OXFORDSHIRE COUNTY COUNCIL'S RESPONSE TO CONSULTATION ON THE FOLLOWING DEVELOPMENT PROPOSAL

Application no: 21/01630/OUT

Proposal: Outline planning application for residential development (within Use Class C3), open space provision, access, drainage and all associated works and operations including but not limited to demolition, earthworks, and engineering operations, with the details of appearance, landscaping, layout and scale reserved for later determination

Transport Schedule

DRAWING TITLE  
**PROPOSED PEDESTRIAN CROSSING TO CHURCH**

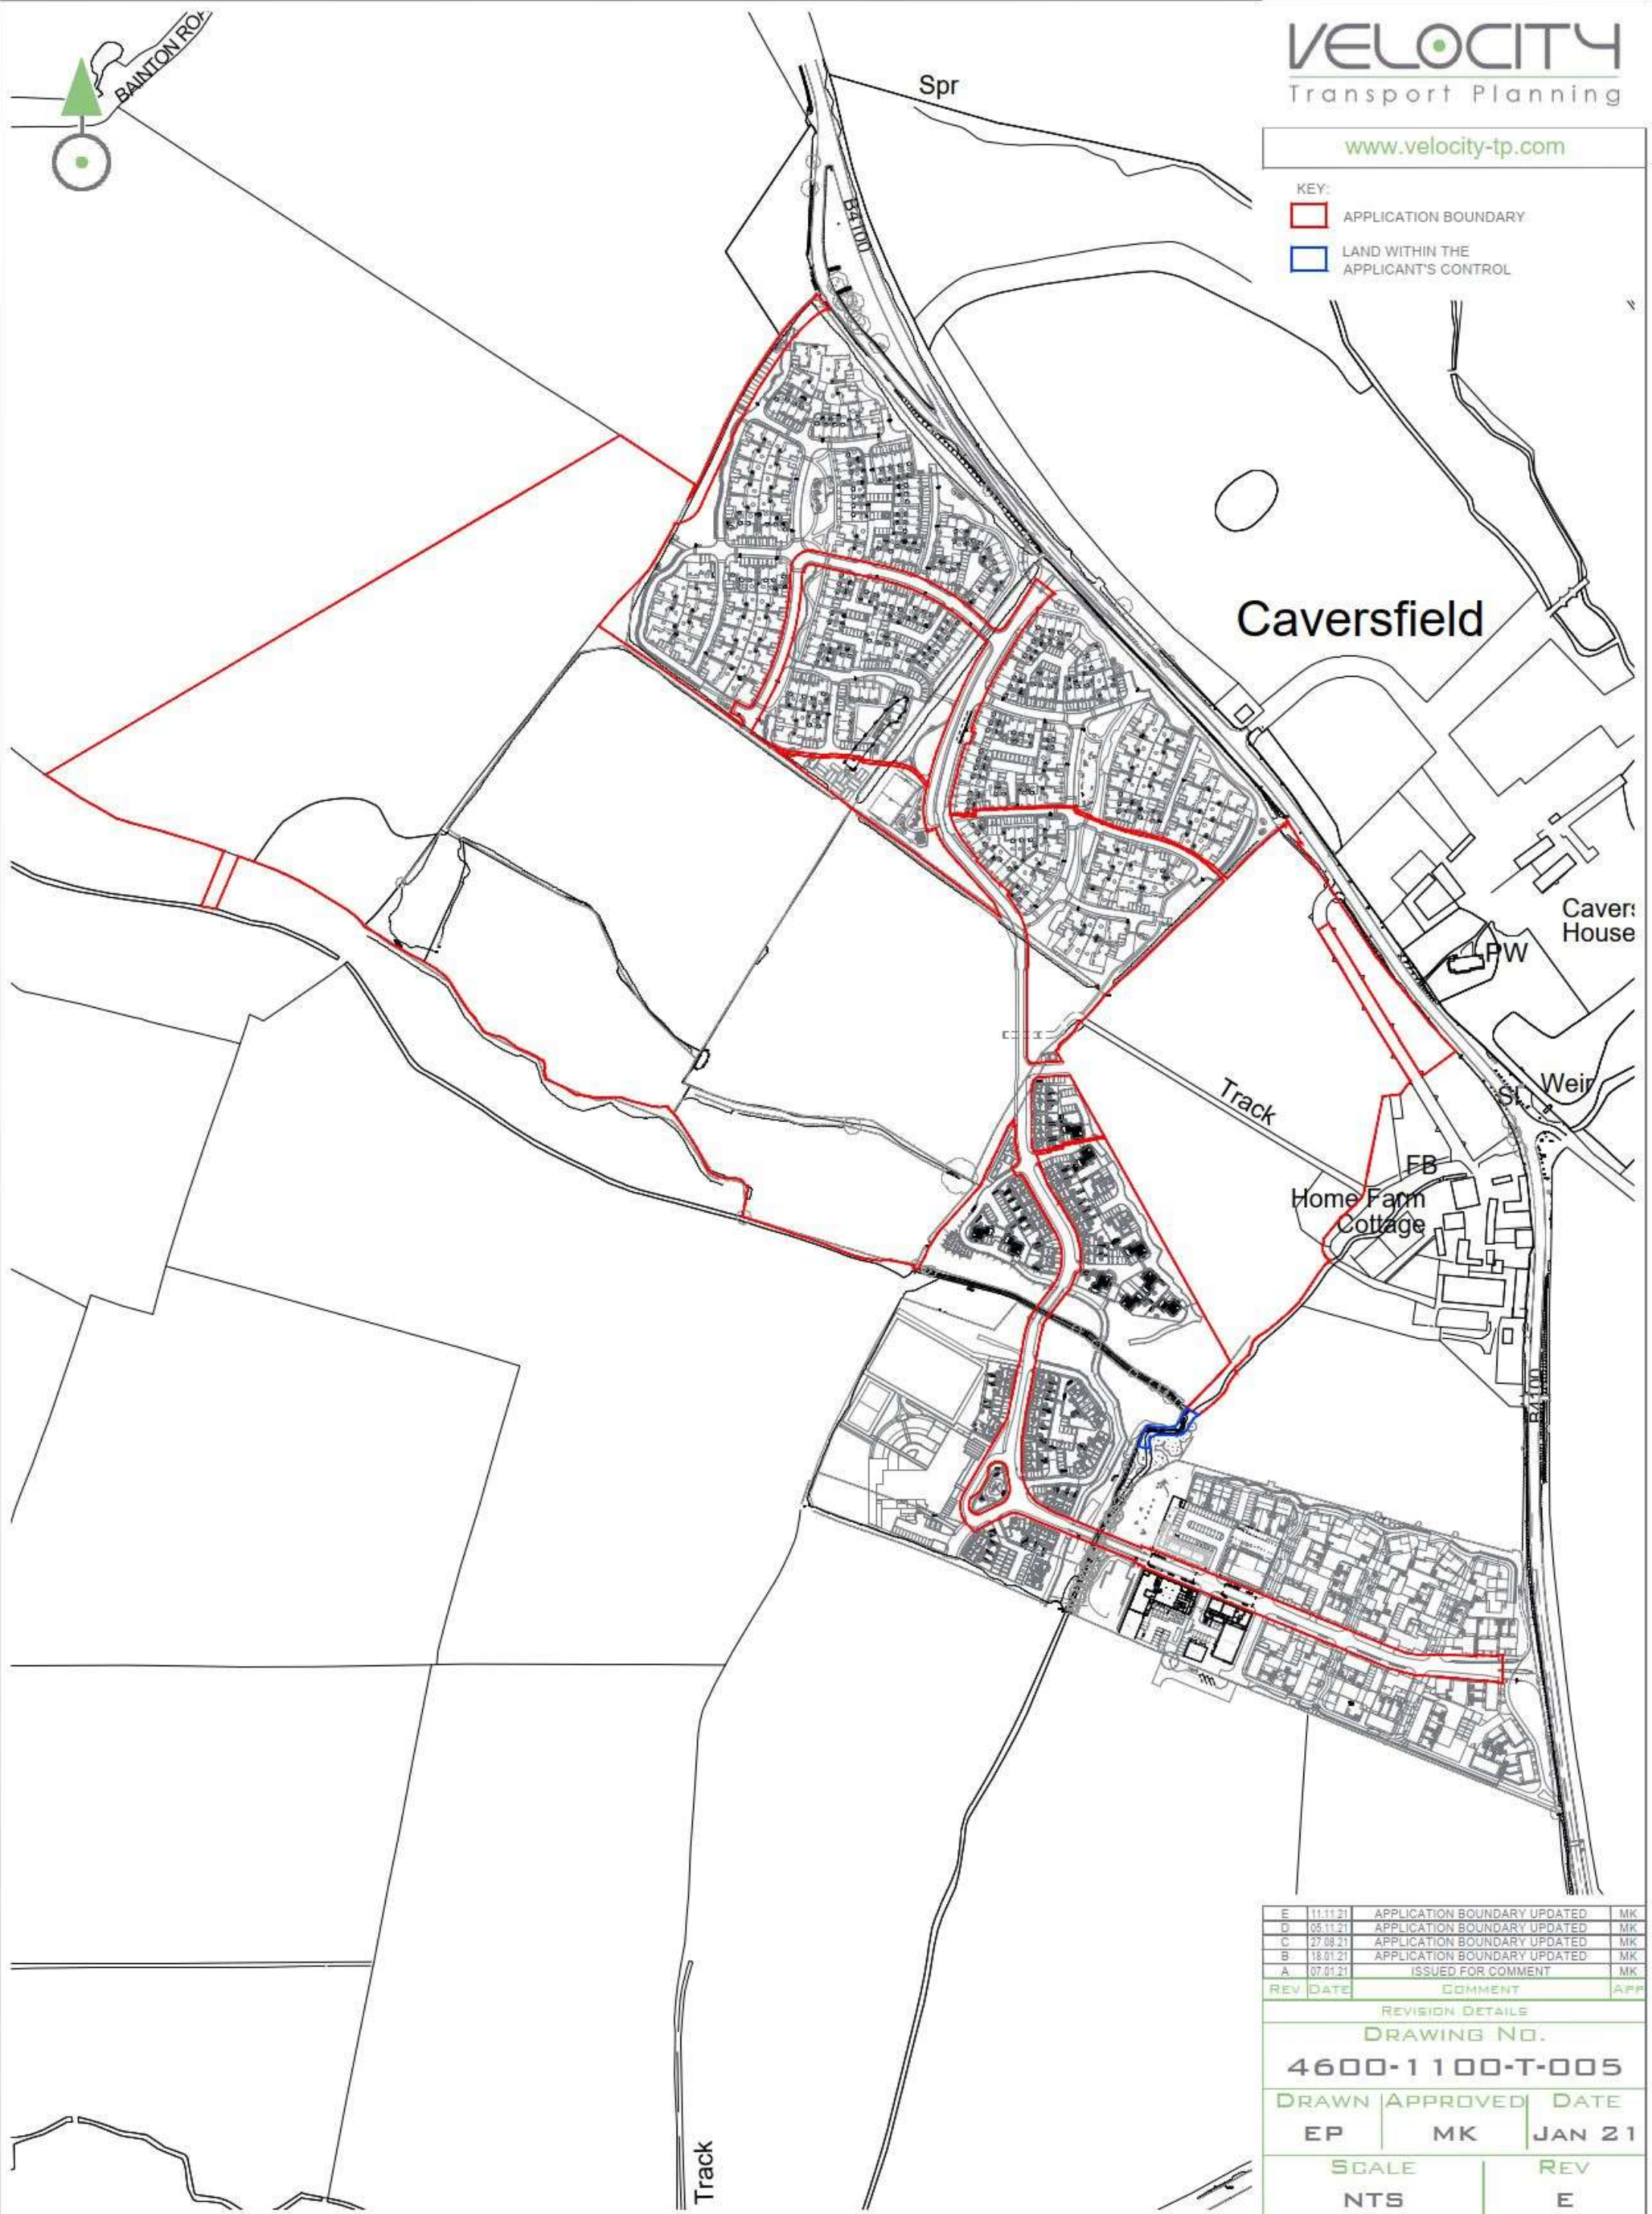
- A pedestrian crossing and connecting footway is proposed to Caversfield Church, which would be delivered by the developer.
- Pedestrian/cycle connections out of the site are shown as 'potential' on the parameters plan. There should be a firm commitment to provide these. Some connection points are not shown and this should be addressed.

REVISION DETAILS		
DRAWING NO.		
<b>4600-1100-T-011</b>		
DRAWN	APPROVED	DATE
EP	MP	JAN 21
SCALE		REV
AS SHOWN @ A3		E

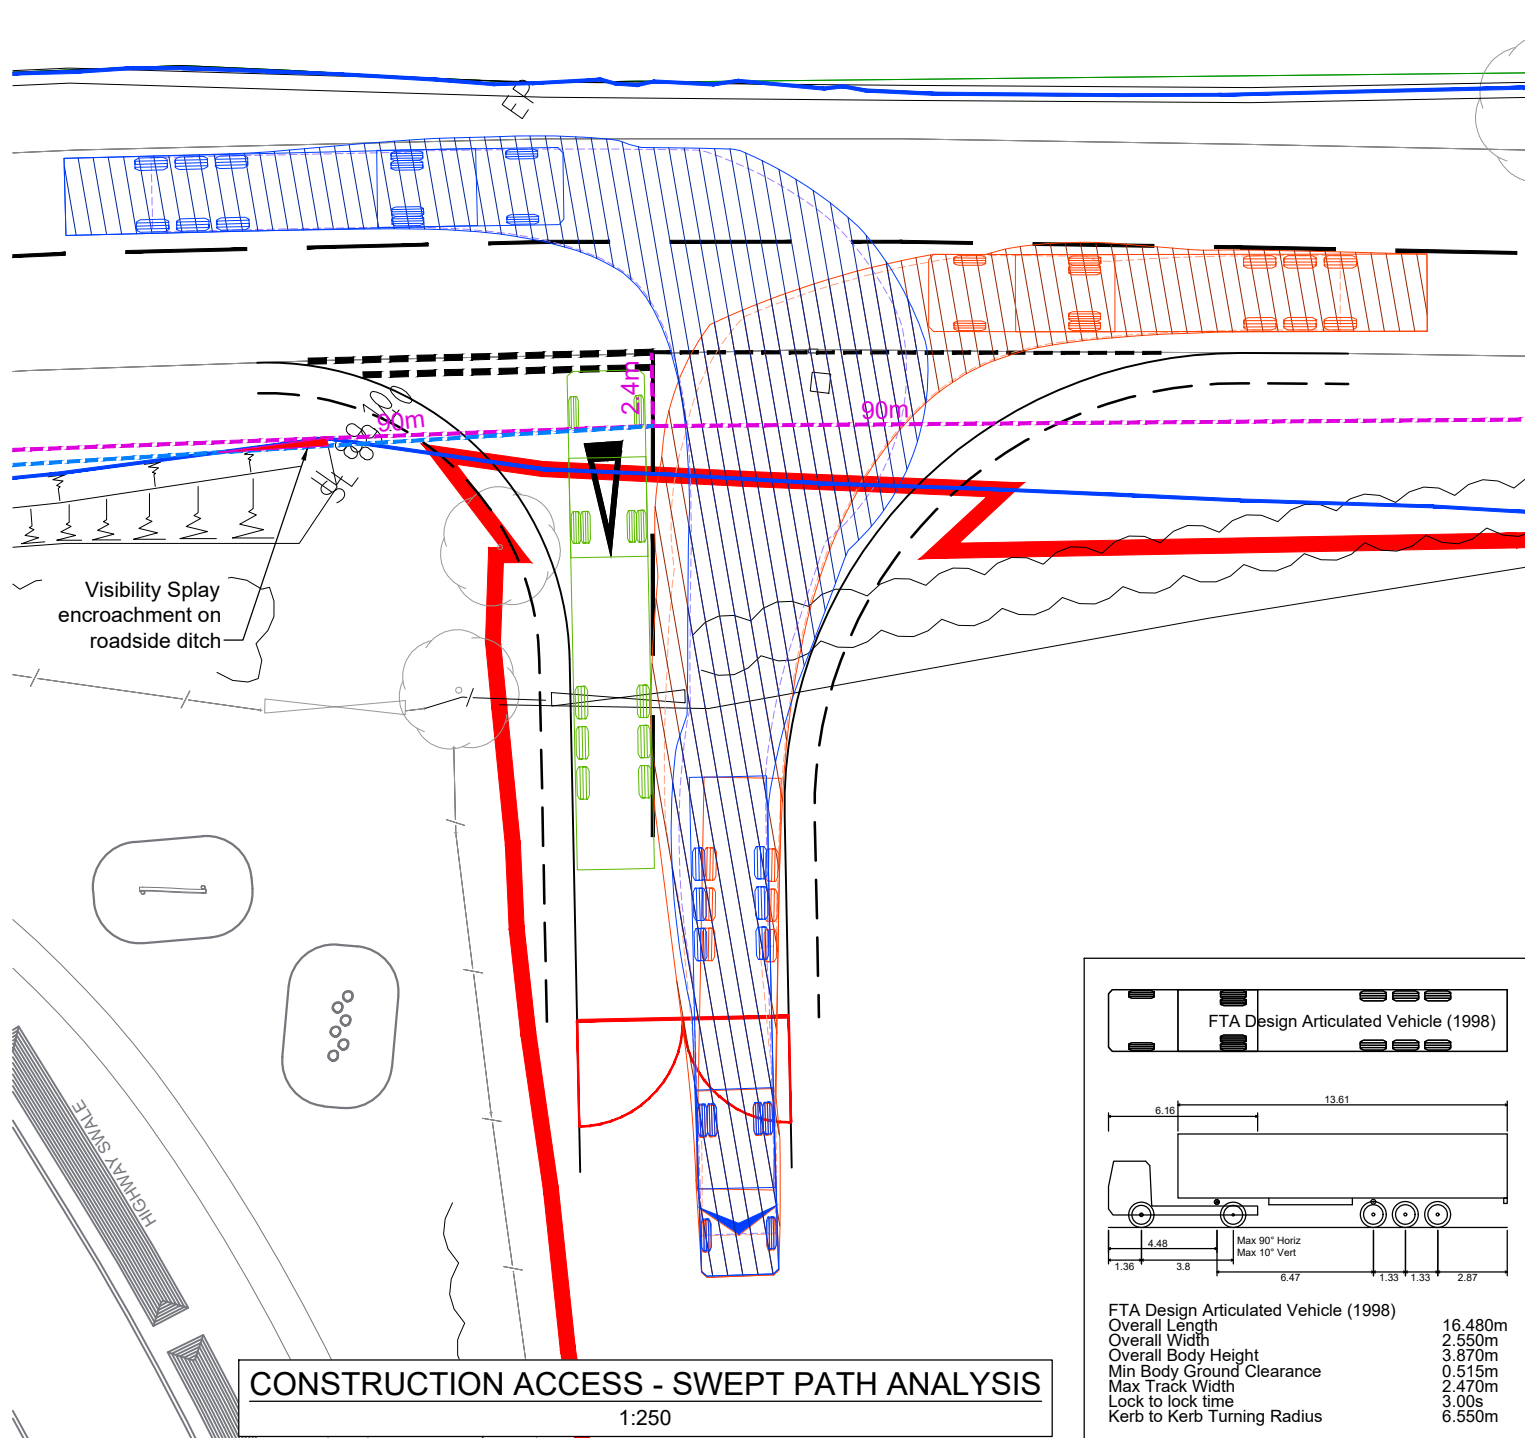
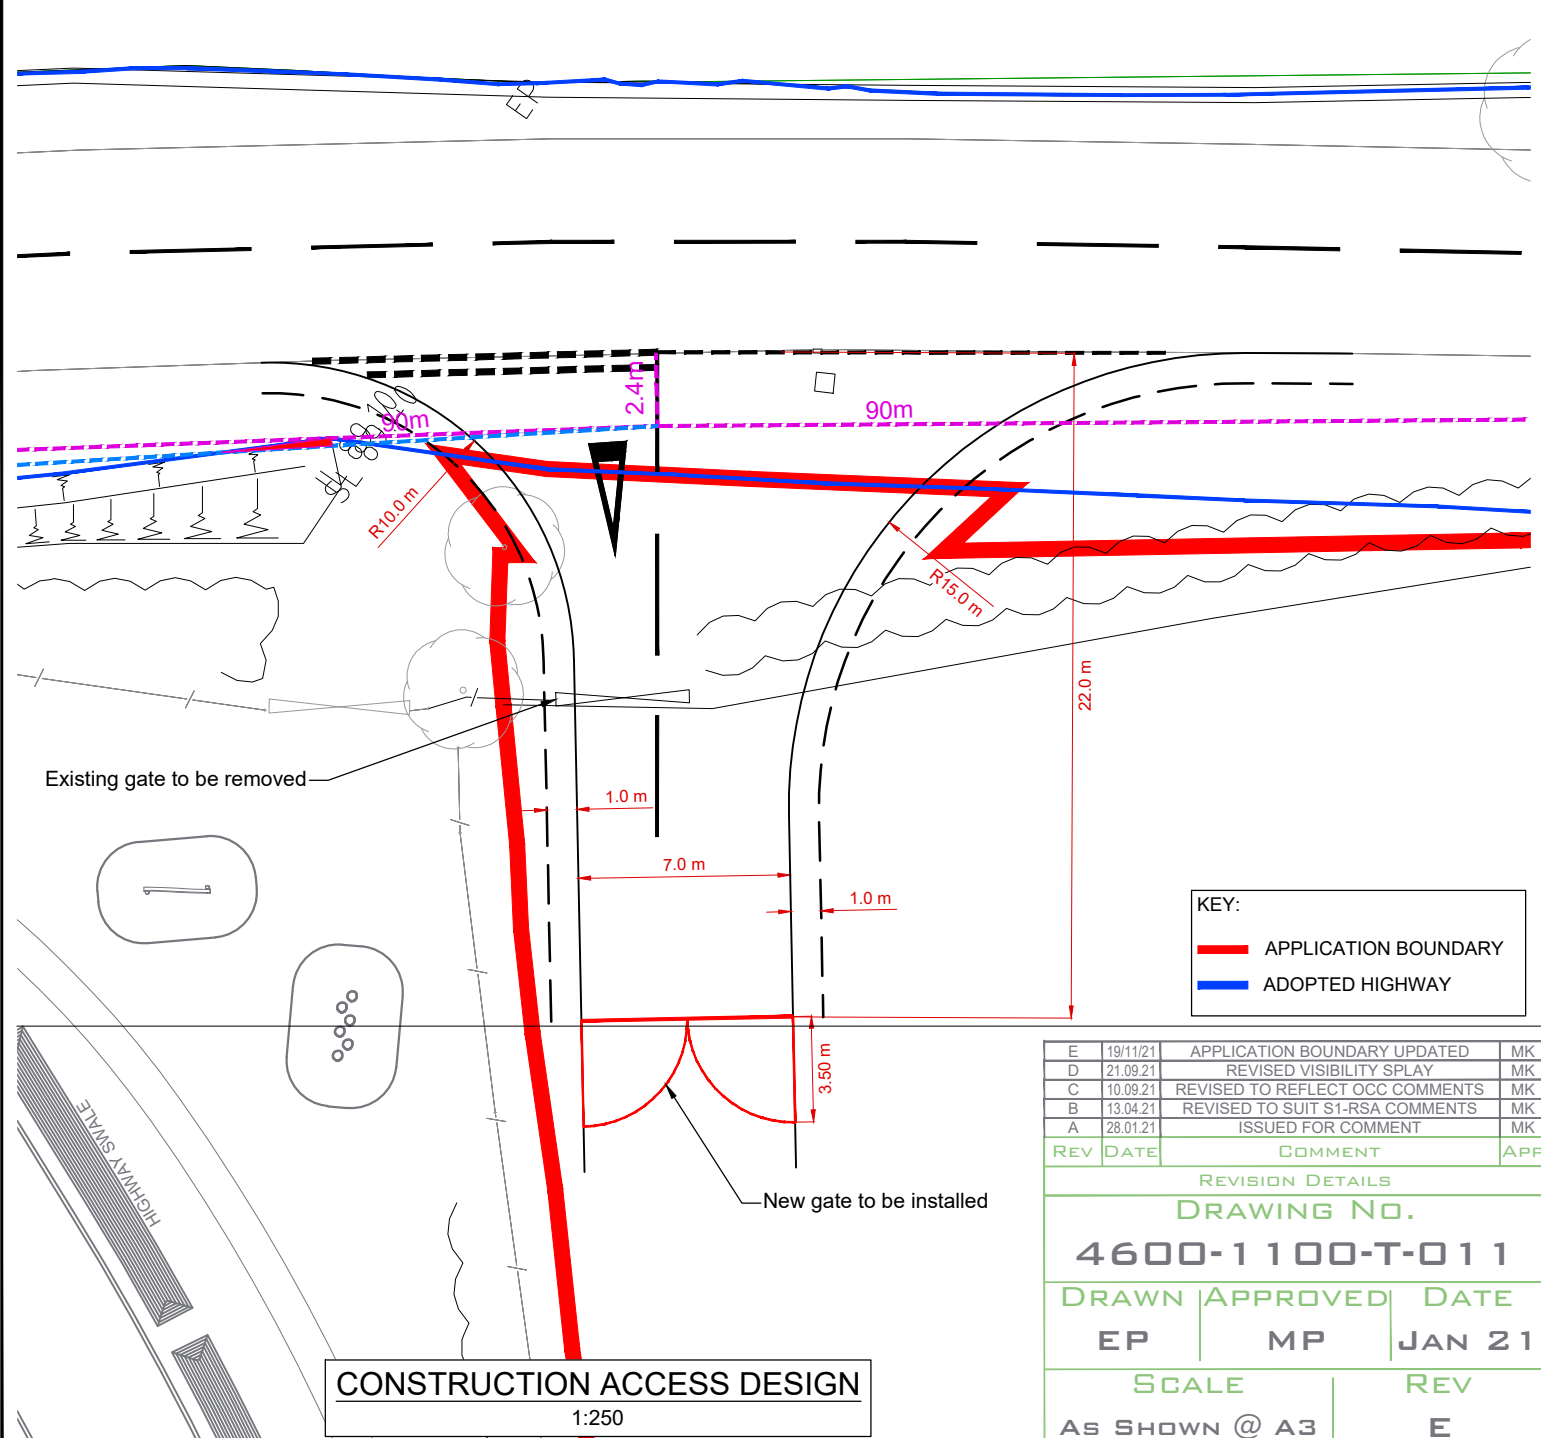
- The proposed construction access from the B4100 into the eastern parcel would require a temporary speed restriction to 30mph, together with additional mitigation, due to potential visibility restriction posed by the ditch.

6	Access D – swept path analysis required of full route, and 2m footway required both sides	Argues that for the roads to be adopted by OCC within the existing Elmsbrook, SPA would need to be approved anyway, so applicant does not need to provide it. Further argues that footway not needed on both sides due to discontinuous footway as the road carries on into Elmsbrook, and the fact that there would be little demand for walking in this direction.	I accept that these points are reasonable.	Yes
7	Construction access to Eastern parcel –	A revised drawing has been provided showing a	This would be acceptable subject to a temporary

visibility splay crosses non highway ditch that is not within red line	visibility splay of 90m to a position 2m away from the kerb-line, which is achievable without crossing the non-highway ditch.	speed restriction to 30mph in the vicinity of the access.	
8	Construction access to western parcel – access through residential parcel not suitable. Swept path for max artic required for access C.	Alternative access proposed off layby on B4100, and along western edge of Exemplar site Phase 4	This is a better alternative than taking a route through Elmsbrook roads. However in order to operate safely and without obstruction, a considerable amount of parking would need to be removed from the layby, which would need to be achieved through a TRO. CDC will need to consider any impact on recycling facilities and hot food pitch. The layby is in poor condition, and, while sufficing as a layby, if it is to become part of a haul route it will require improvement by the developer prior to use. There is a large ditch that would require to be culverted. An appropriate design of sufficient capacity would need to be approved by the adjacent riparian landowner and CDC as Land Drainage Authority. Access to the adjacent public right of way that leads from the layby should be facilitated and improved. A TRO would also be required to ban right turns into the layby, and additional warning signs would be required. Further details should be required by condition and the arrangements should be	Partially
